**From:** Jane Forder <jane.forder@west-norfolk.gov.uk>  
**Sent:** 14 January 2021 15:16  
**To:** Planning EConsultation <planning.econsultation@West-Norfolk.gov.uk>  
**Cc:** Natacha Osler <natacha.osler@west-norfolk.gov.uk>  
**Subject:** Fw: Planning Application 19/01540/F

Conservation Team Comments.

Object to the current proposal.

DRAWING TITLE
 PROPOSED ELEVATIONS AND BLOCK PLAN
 WITH SECTION B-B

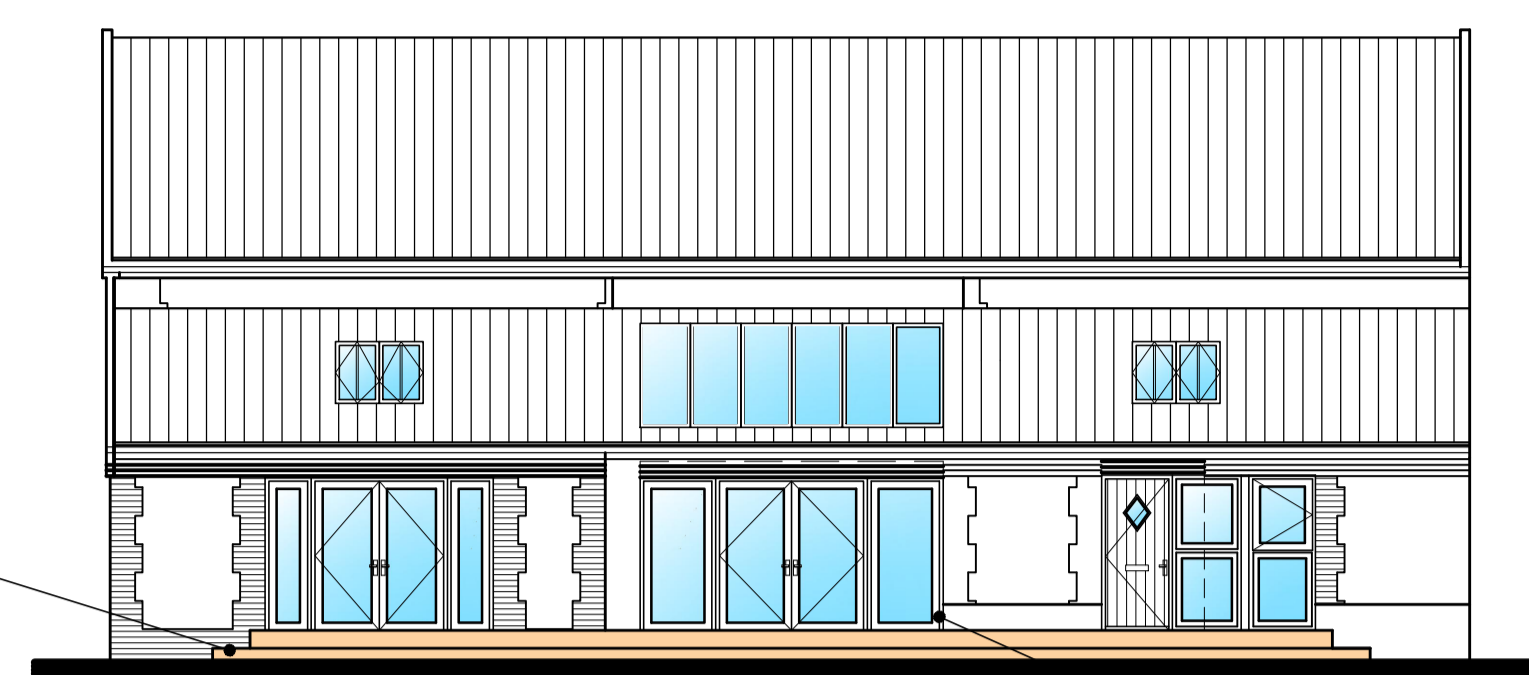
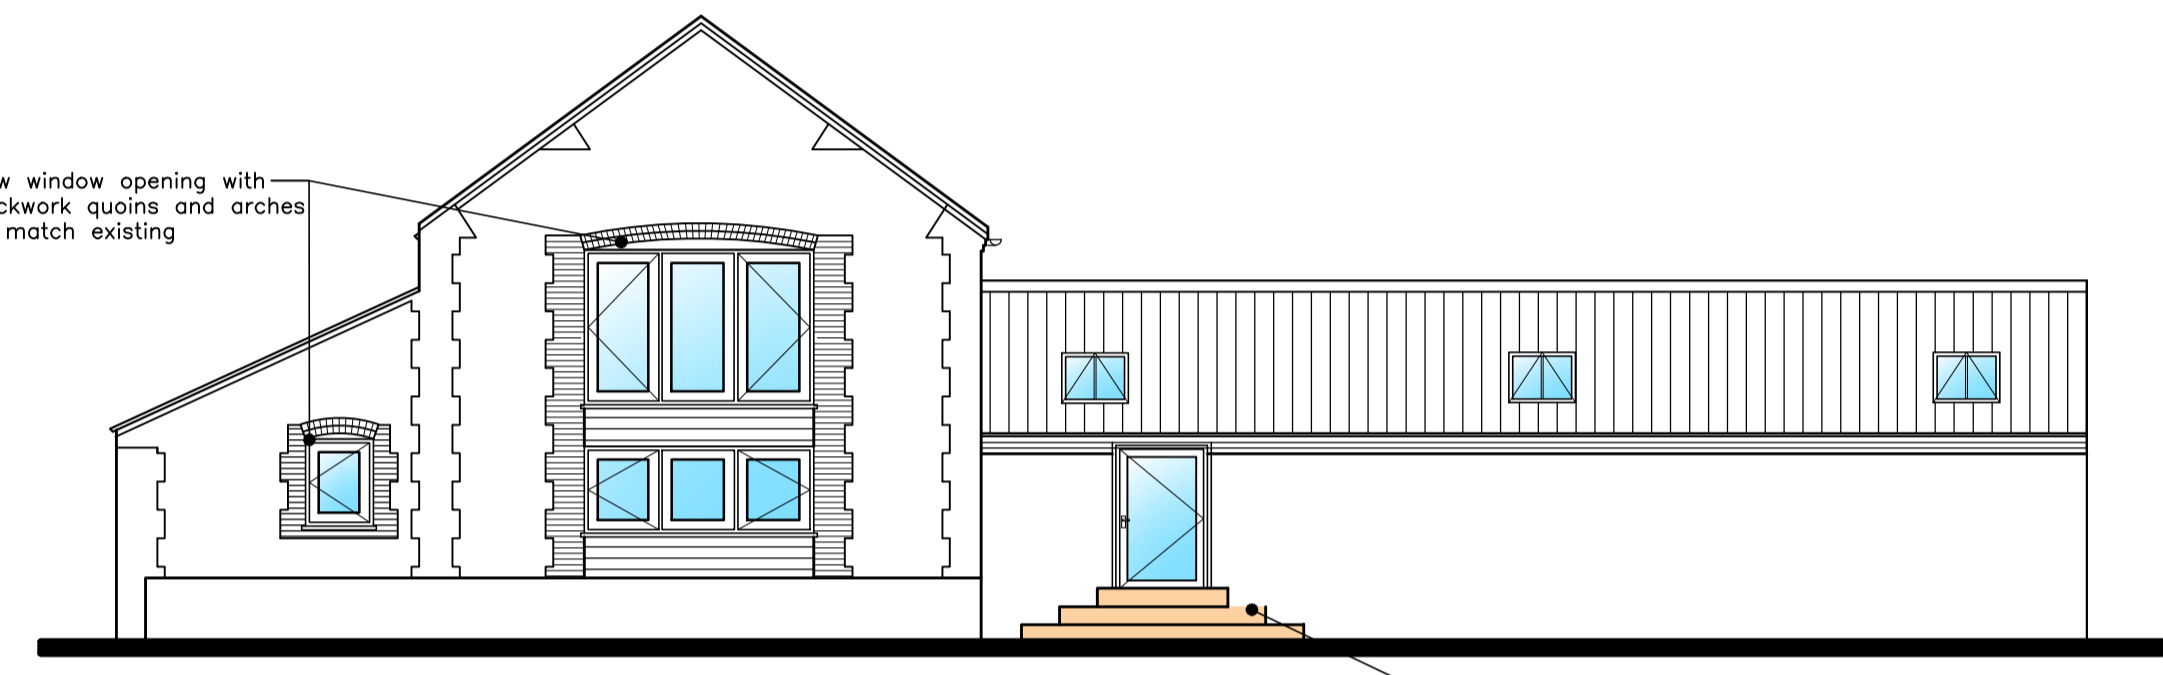
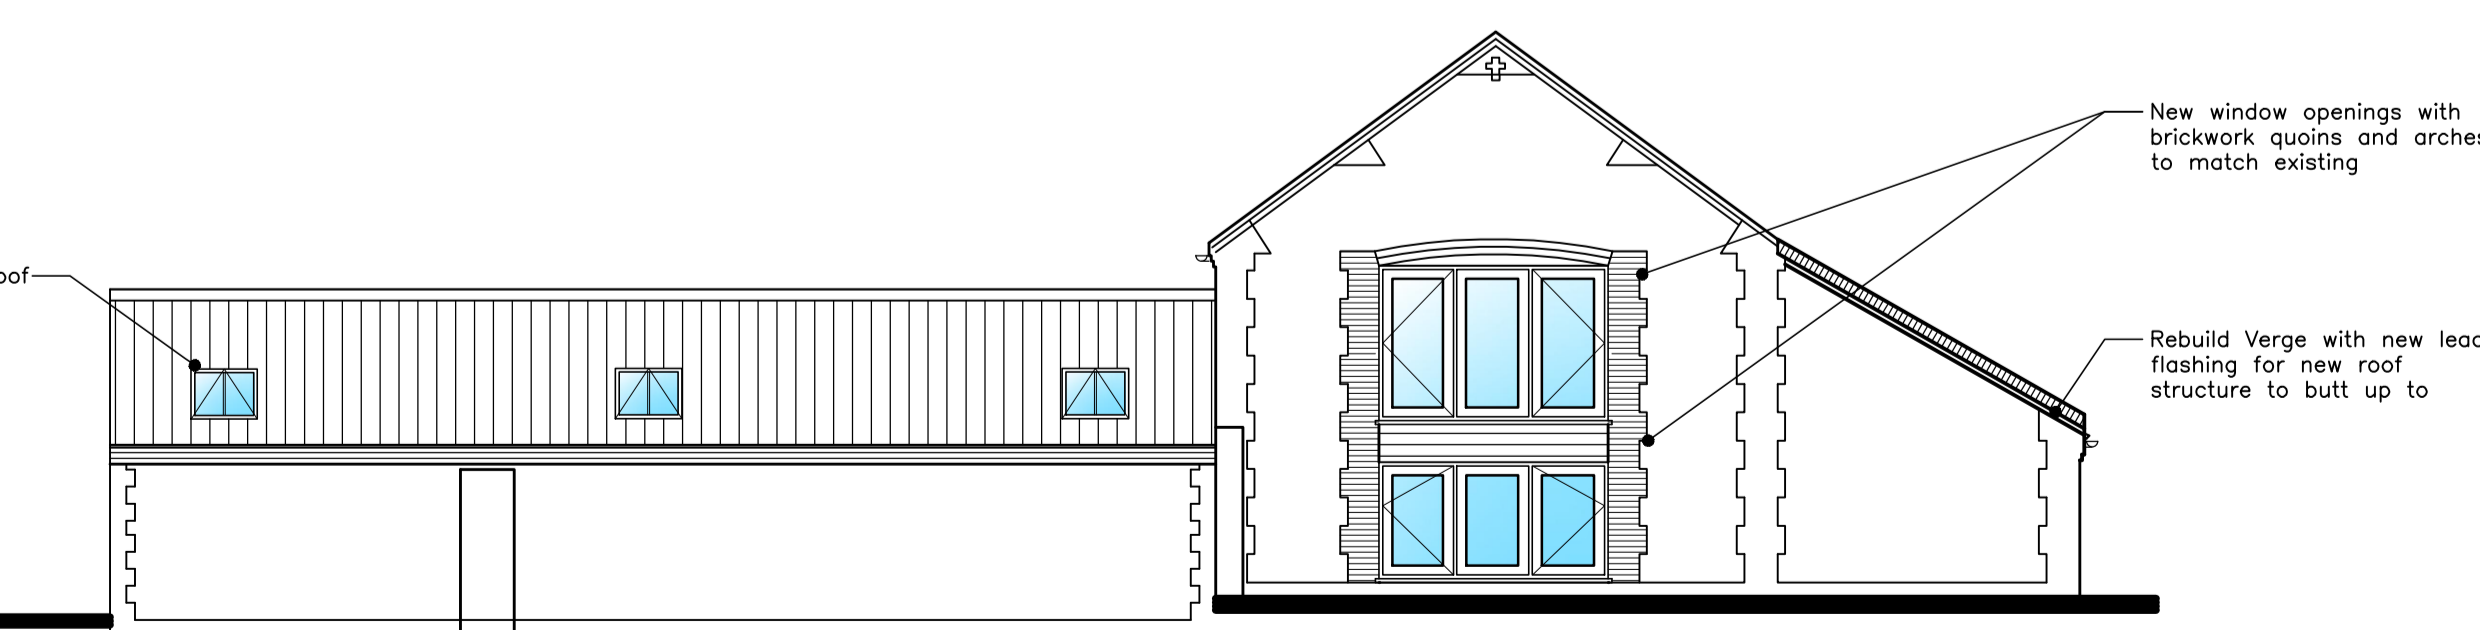
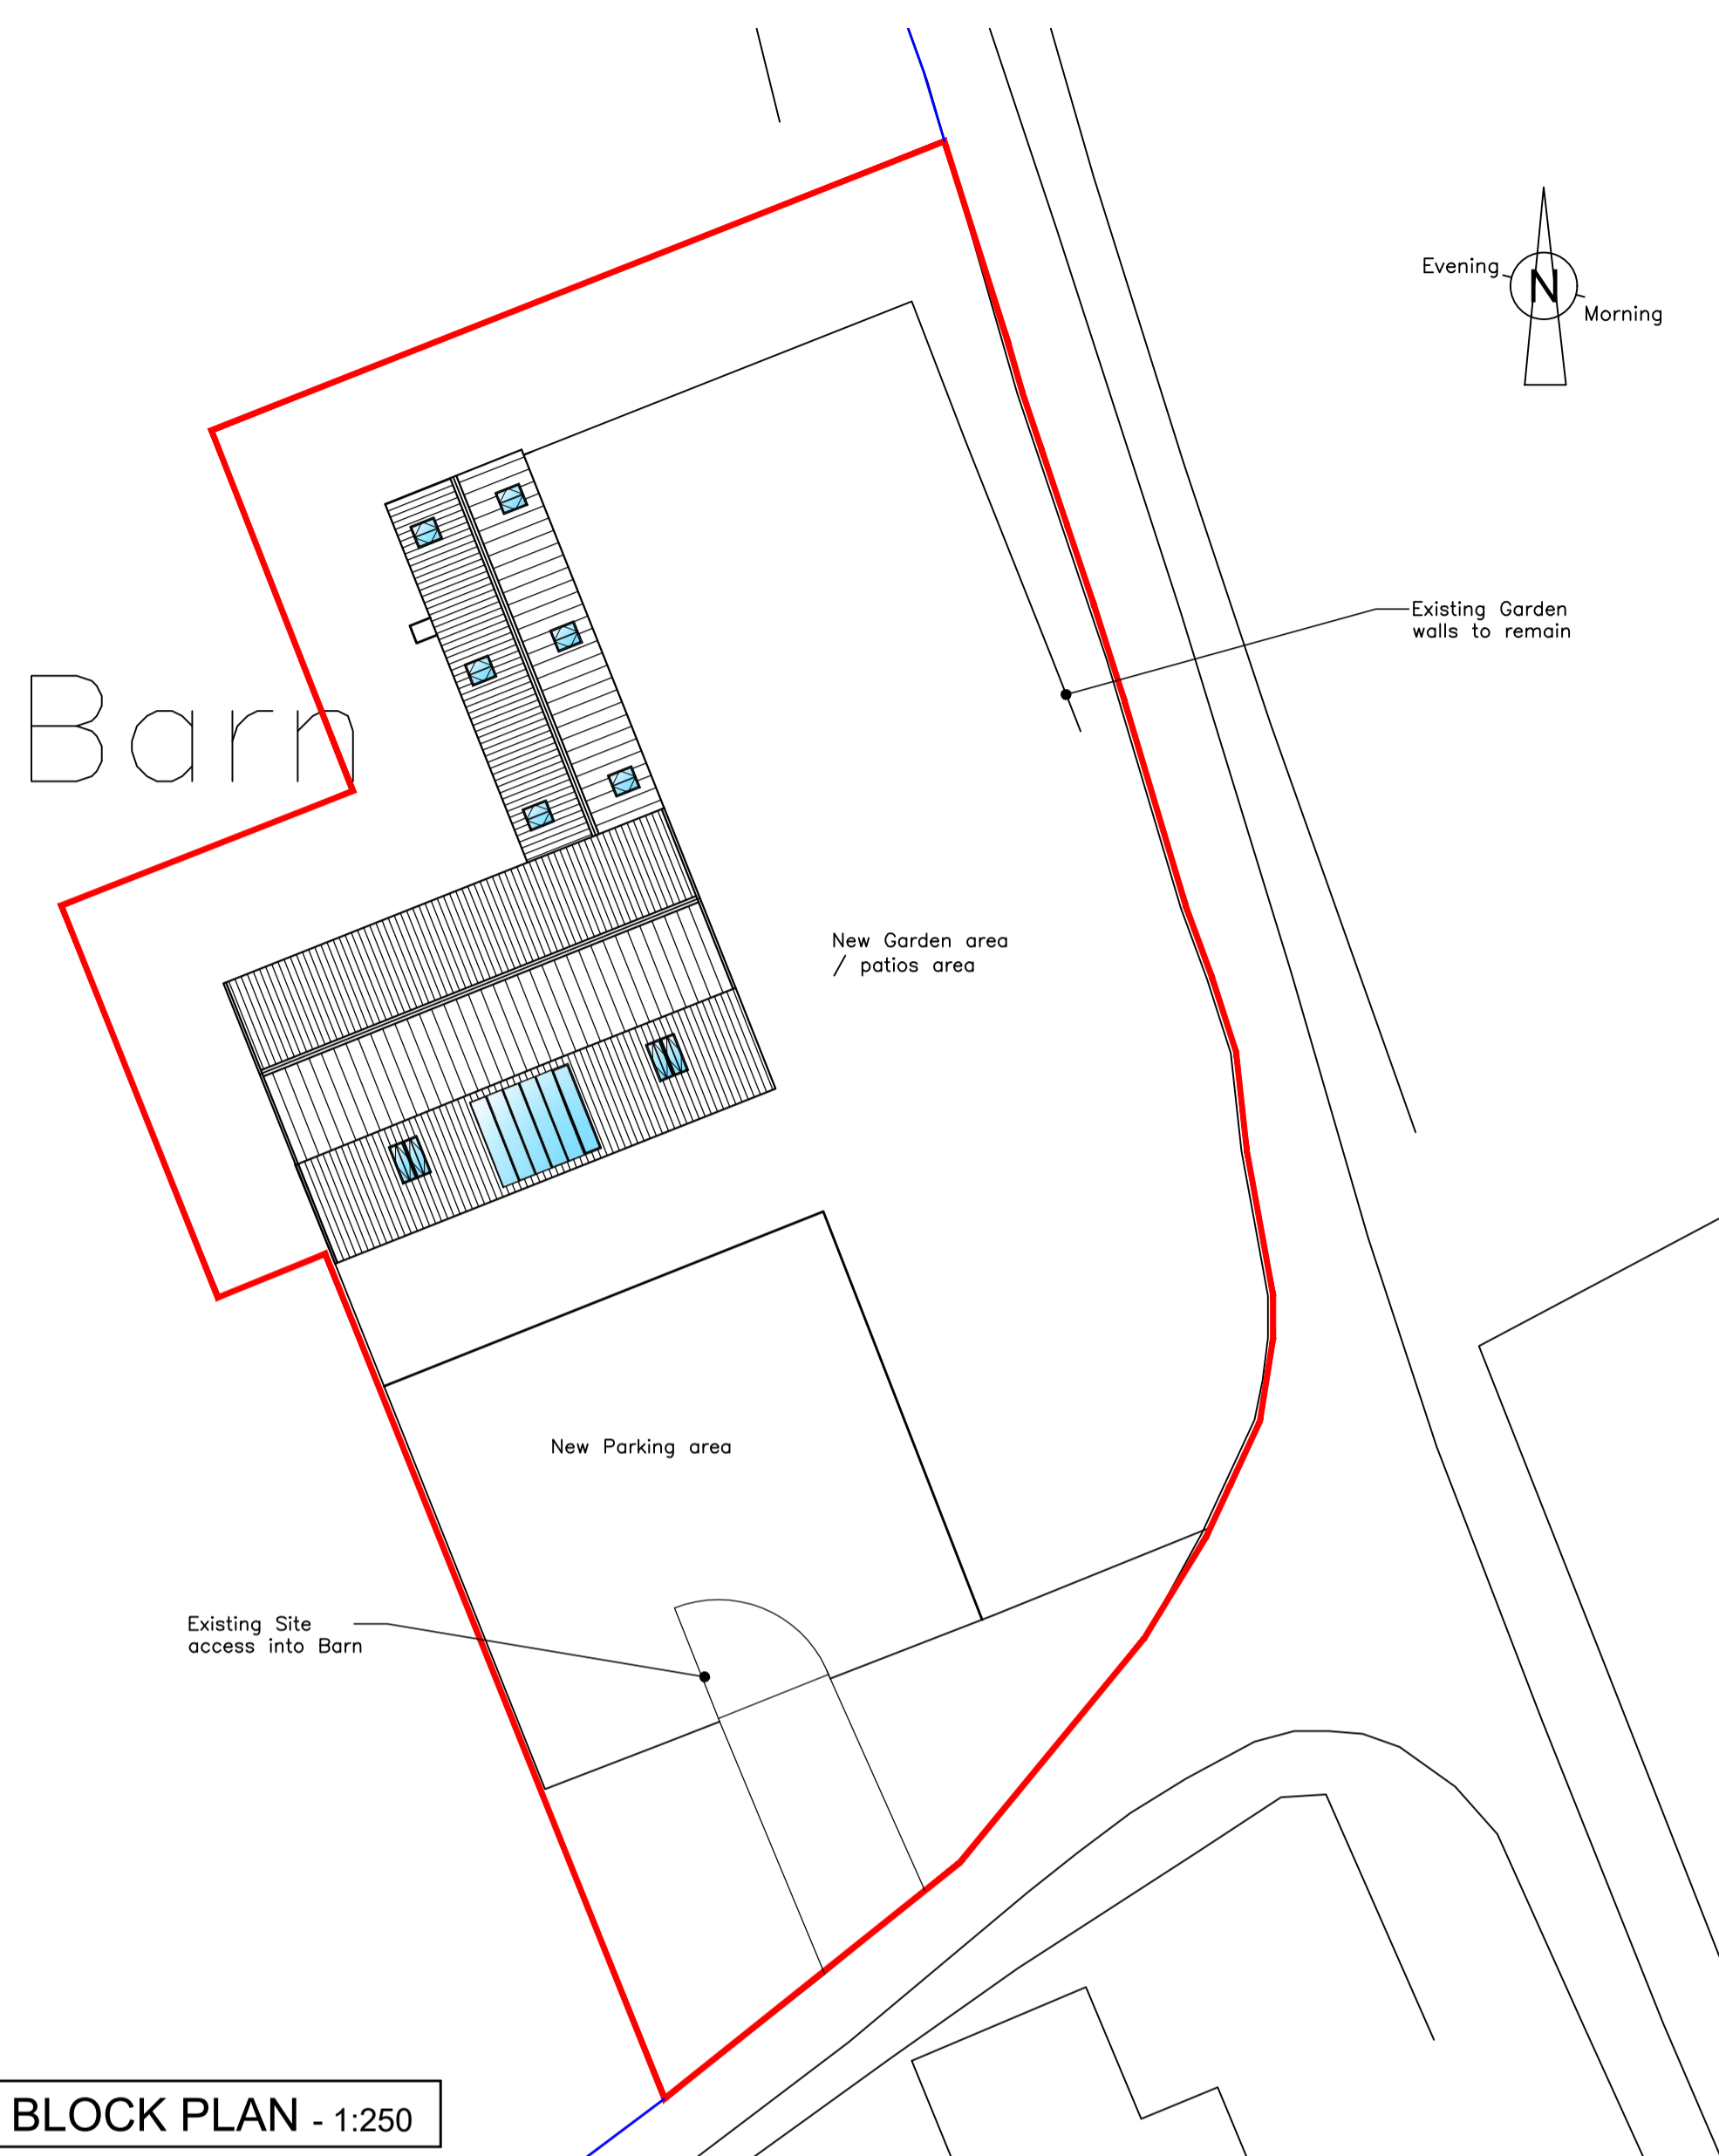
Maximising the use of existing openings by planning internal spaces around them and limited the formation of new ones will help retain character. Where new openings are added, or new windows inserted within existing door openings, great care needs to be given to their placing and design.

The roofs of farm buildings are often highly visible in the landscape. Farm buildings rarely had any form of glazing at roof level. Therefore, the use of multiple badly positioned rooflights can have a detrimental impact on the character of the farm building and the landscape.

The window and door fenestration and the use of multiple roof lights of this scheme has a detrimental impact on the building and the landscape and does not accord for the NPPF.

I would therefore suggest that this scheme should either be withdrawn or significantly amended to accord with the above national guidance.
